PLANNING AMENDMENT

Application No. **H03/0243/00/A1**
 Date Registered **15 NOV 2004**
 Case Officer **RC**

Amendments to conservatory change in size, design, roof
reduced and wood grain upvc

11. A1

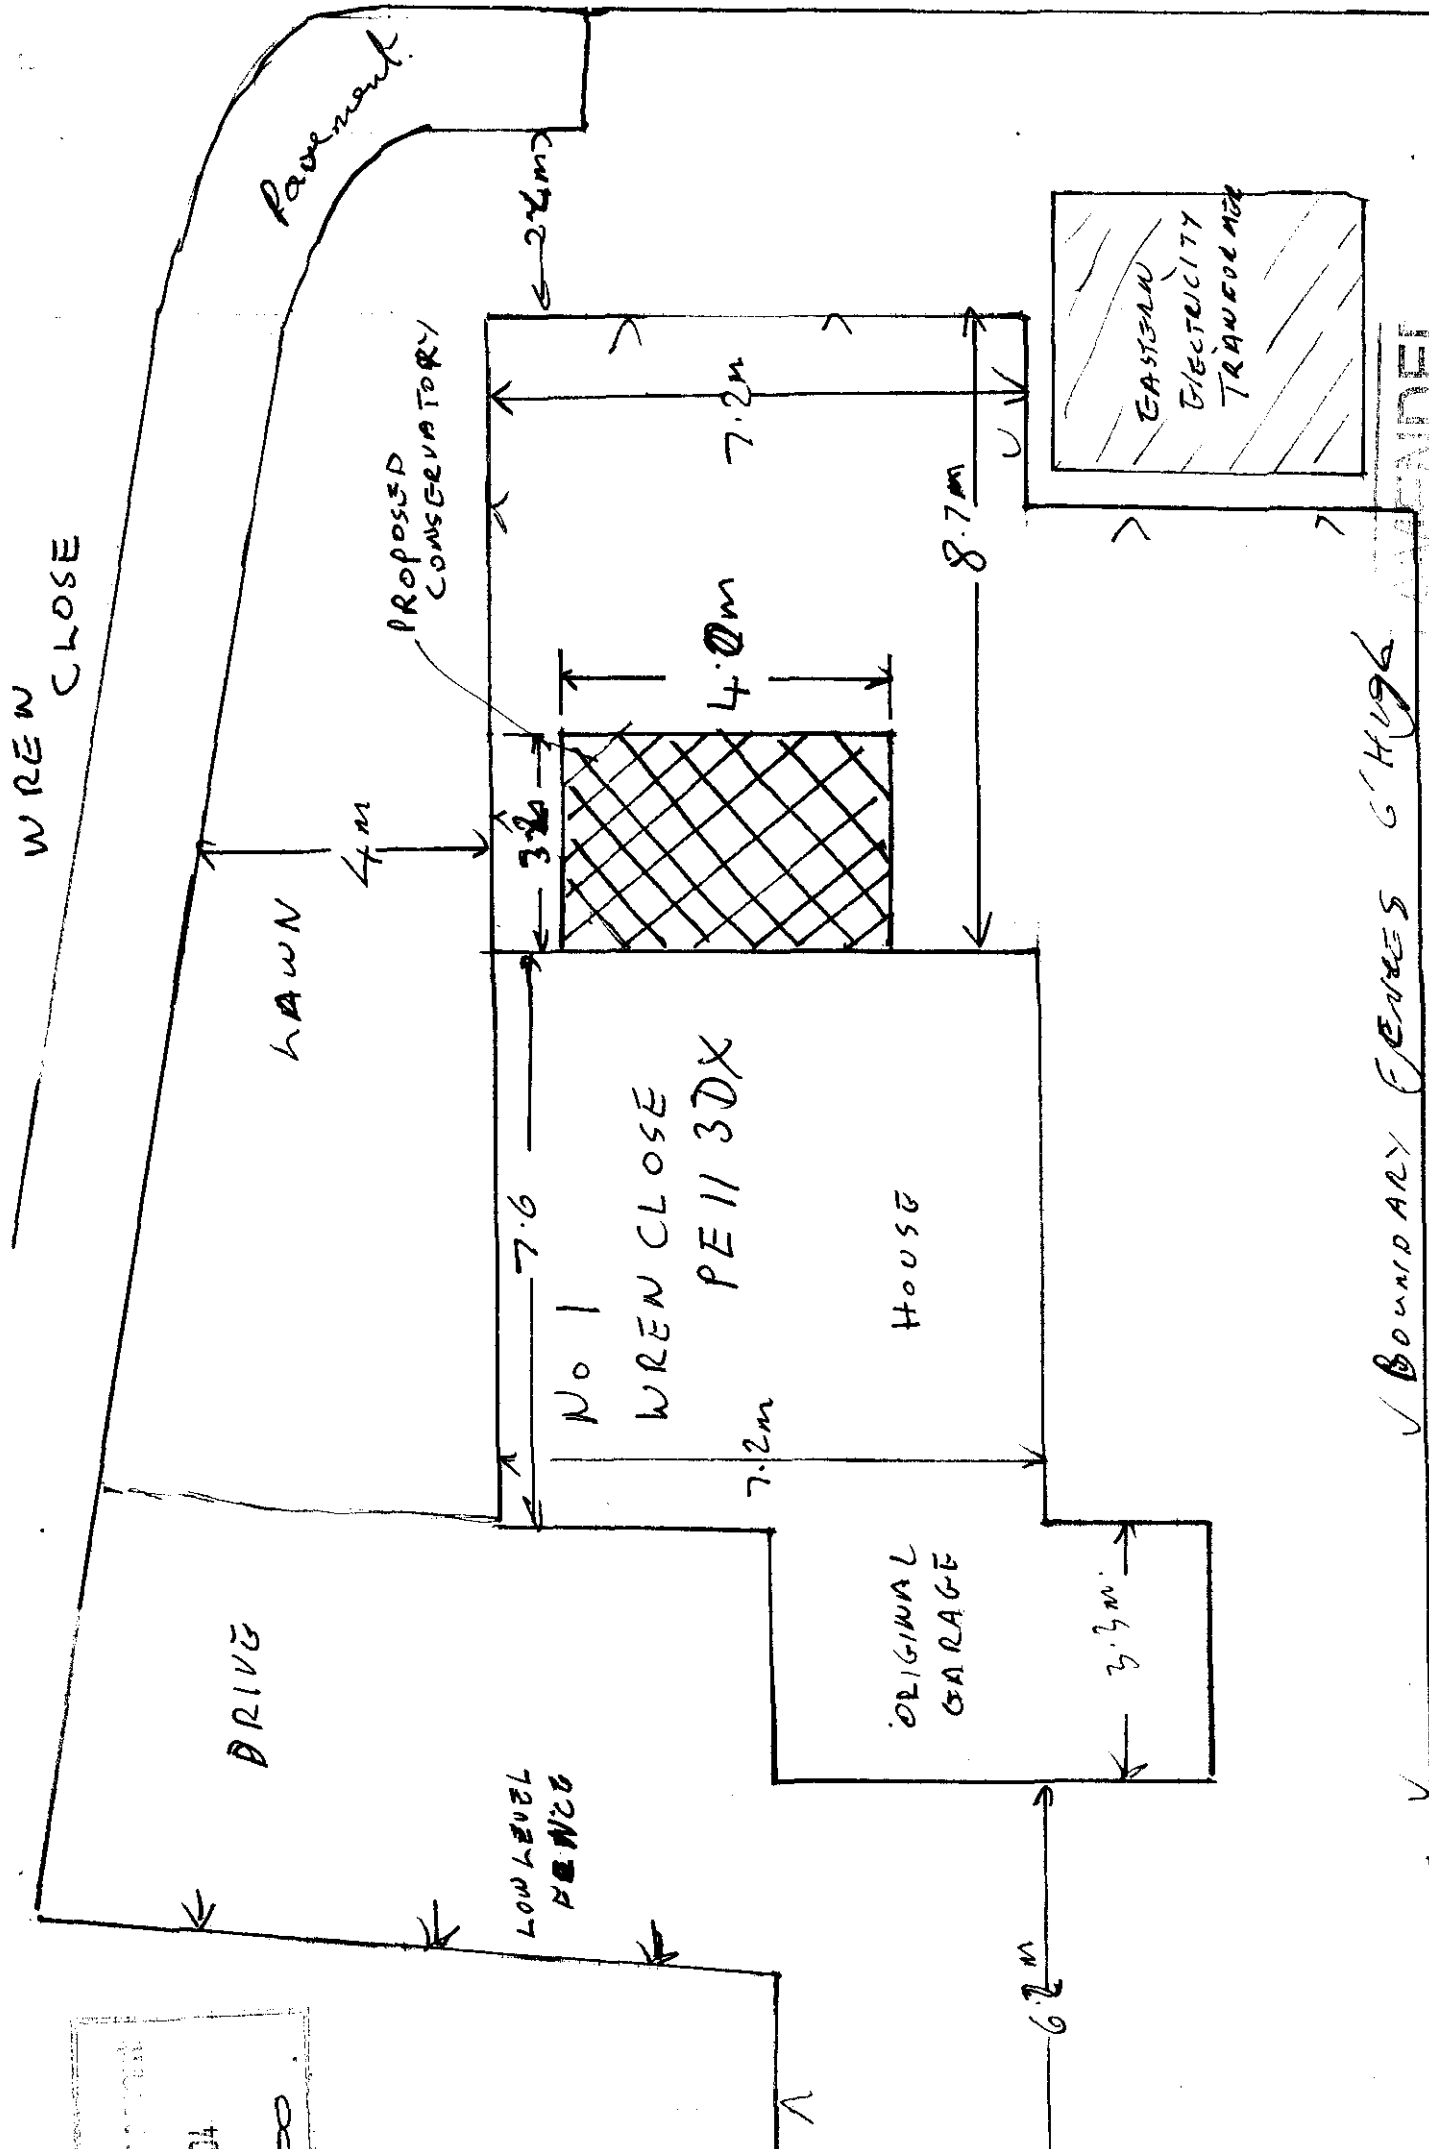
*Conservatory,
 change in size, reduced
 end design change. Wood
 grain pvc & different roof*

The amended details submitted in respect of the above proposal have now been considered and there are no objections to the amendment being implemented to the extent described above.
